Our Ref: R/238/13/

8th November 2013

Application for Householder Planning Permission

Development Proposed single storey attached garage with storage over
Location The Old School House Claigmar Road Rustington Littlehampton

Block plan, Scale 1:500

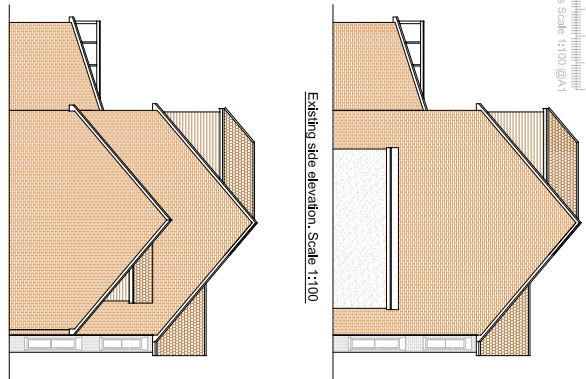
Block Plan

Please submit 1 electronic or 3 paper copies of an amended block/site plan at a scale of 1:500 or 1:200 showing the measurements to the boundaries (and rear boundary)

Proposed ground floor plan, Scale 1:50

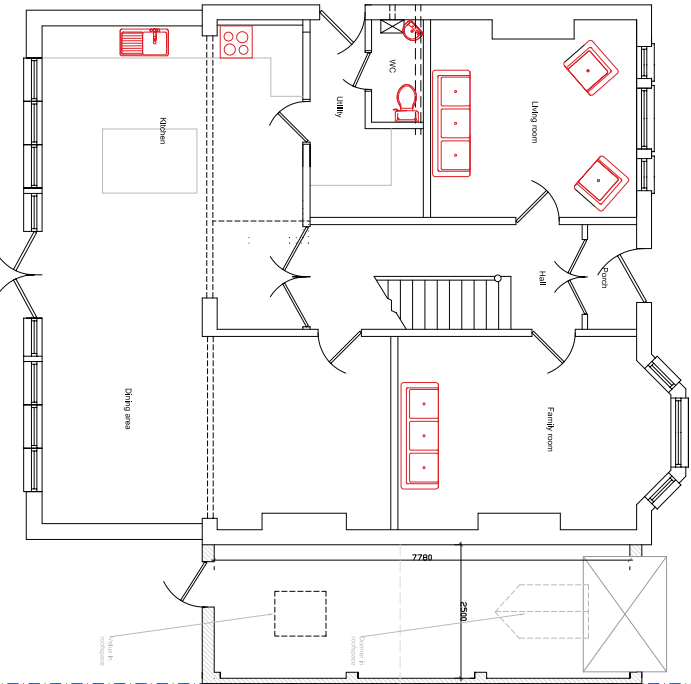
Floor Plans

Please submit 1 electronic or 3 paper copies of clearly labelled floor plan of the storage area at a scale of 1:50 or 1:100. Further details can be found in the National Validation Requirements.
